RE: RKK Lot 2 3402 72nd PI SE 2012-012 Intake

Response to Intake comments:

SHEET No.:
A1.0

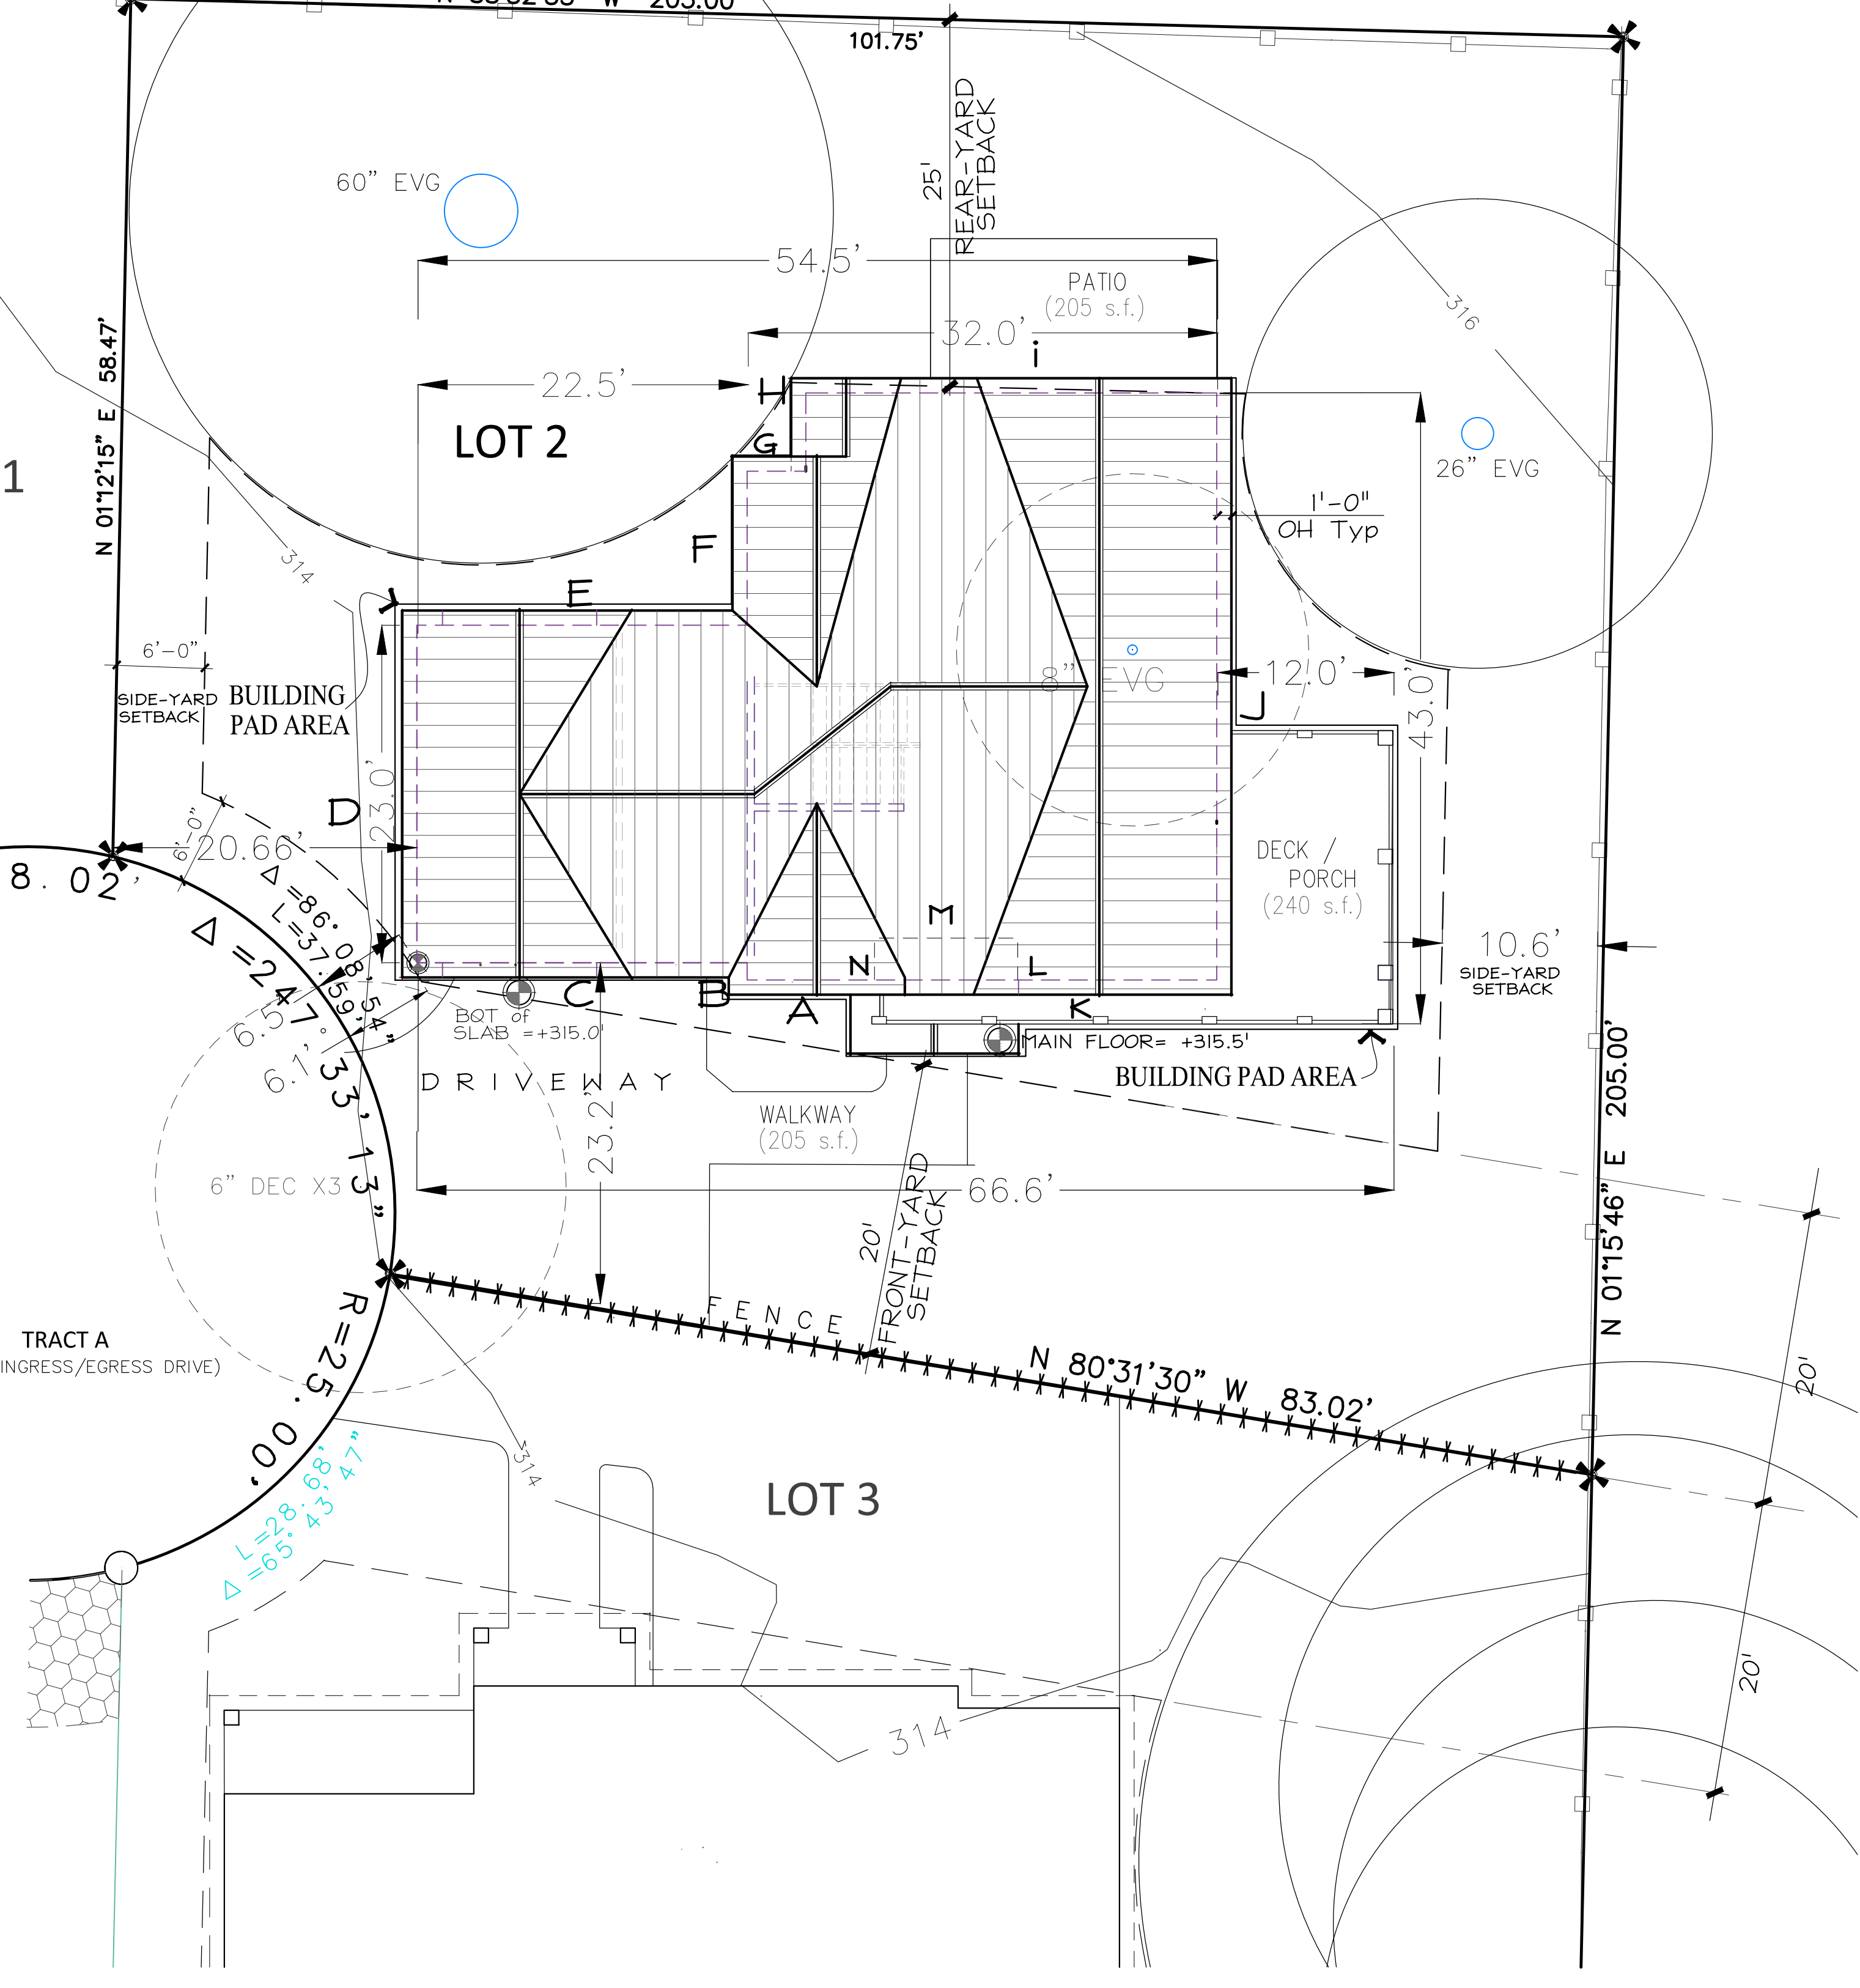
Building Pad Added

ABE K mark added

Front Setback properly noted

SET TITLE:	SCHEMATIC SET
SHEET TITLE:	ELEVATIONS

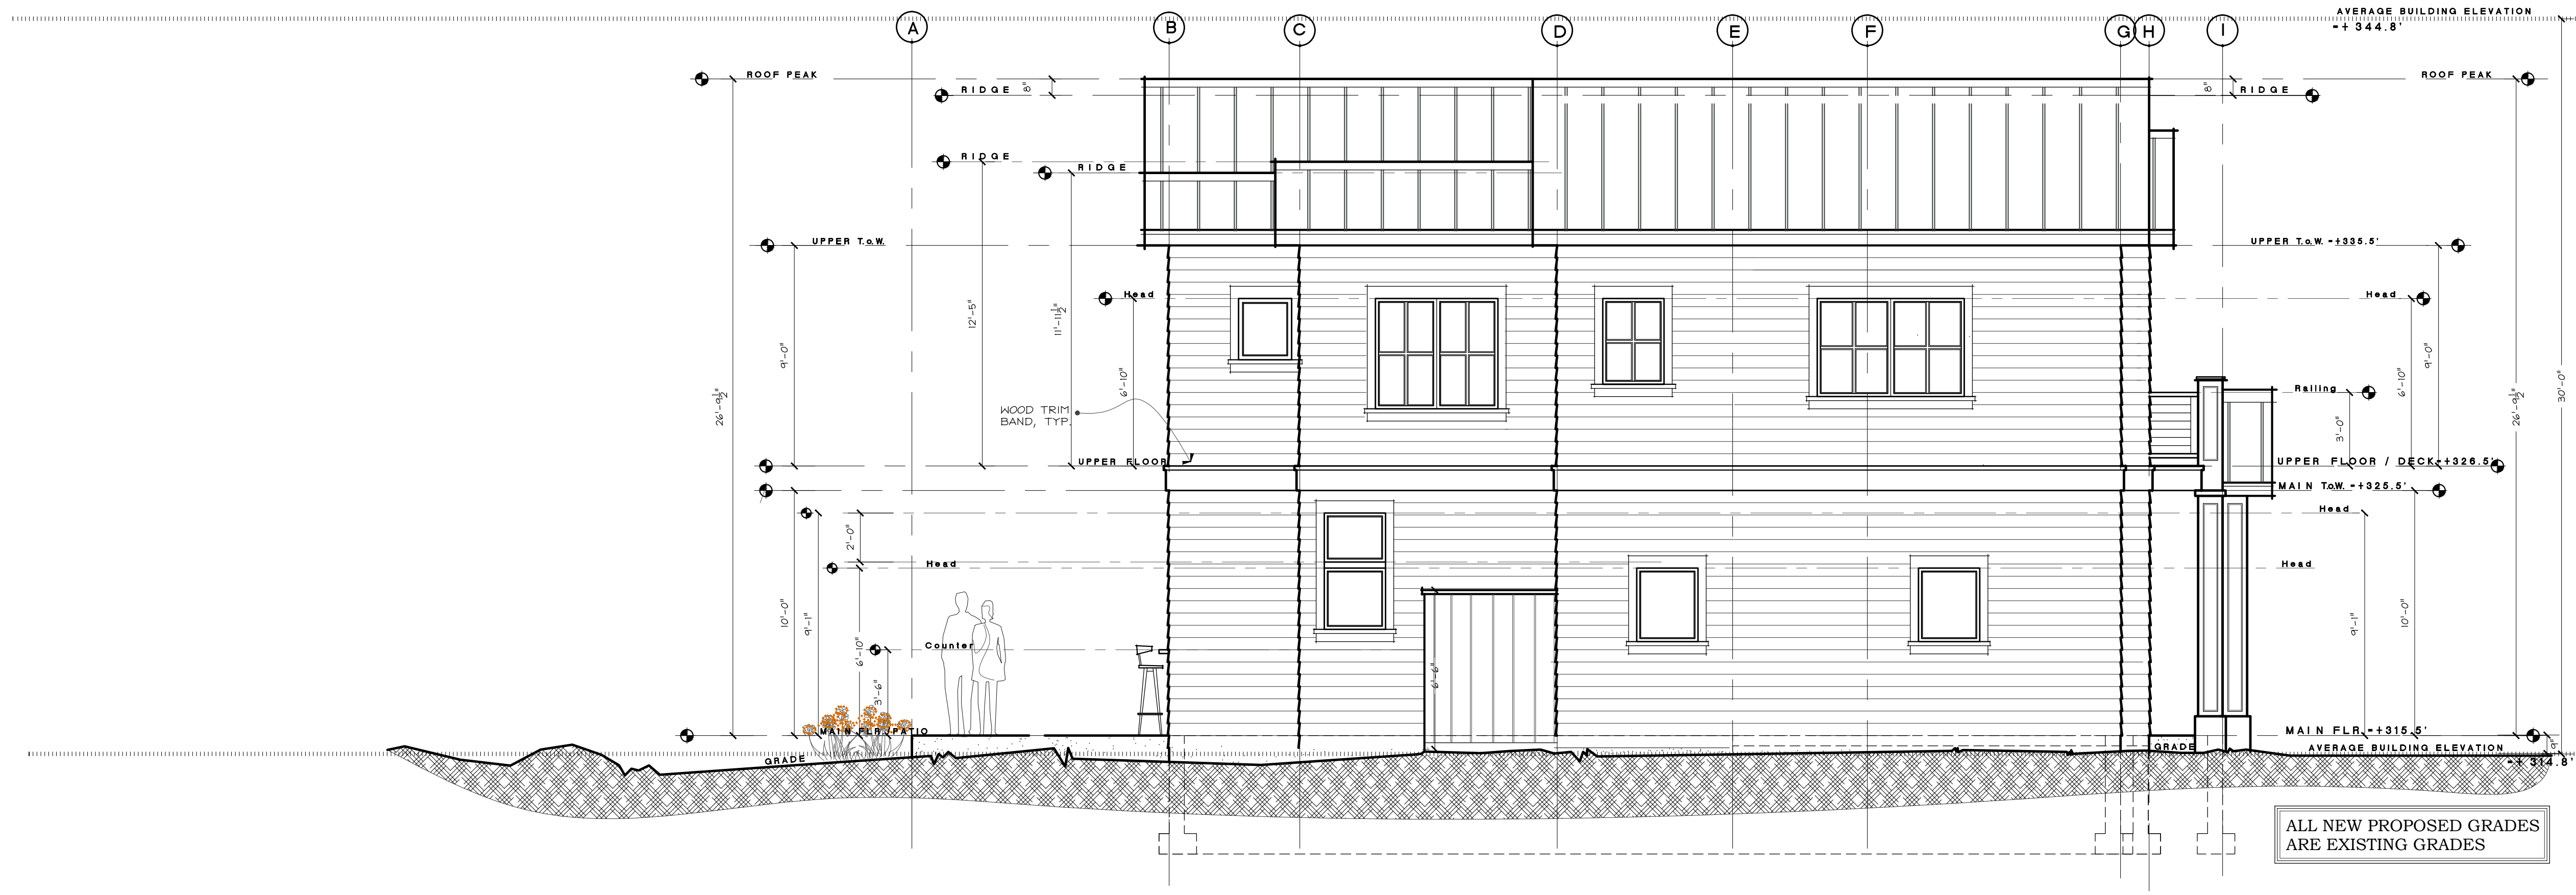
Lot is flat, proposed grade is the same as existing grade. Noted on Elevations
